**To:** FILE  
**From:** Caitlin Cameron  
**Subject:** Application ID: 2014-066  
**Date:** 7/7/2014

Re: 167(185?) Fore Street – Review Comments 2014-066

Department of Public Services

(F) BARRIER FREE RAMP DETAILS
N.T.S.

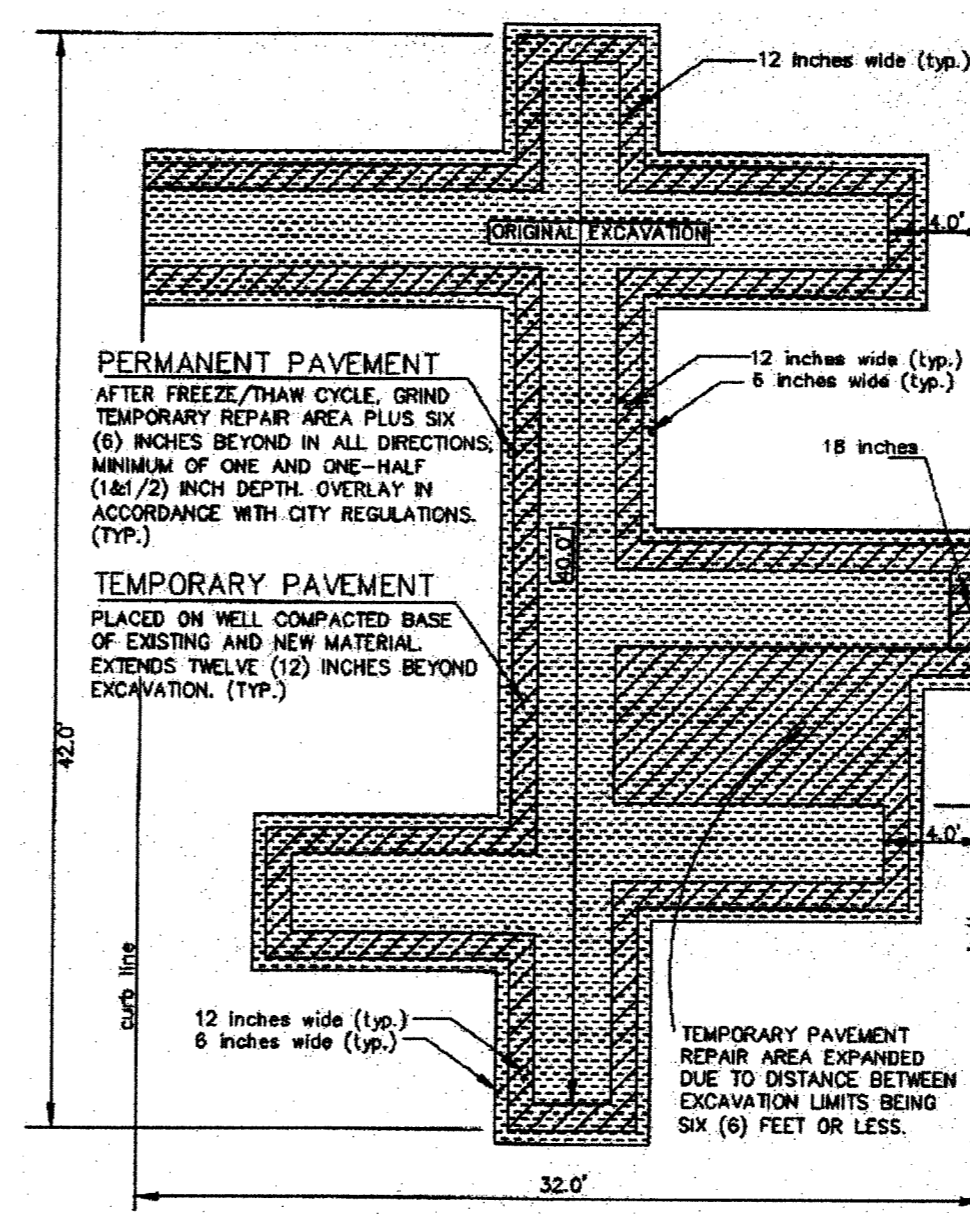
8. Both of the cross walk ramps at the corner of Hancock and Middle Street do not meet current City of Portland standards. The applicant is requested to rebuild these two ramps to meet current City standards.

Comment addressed.
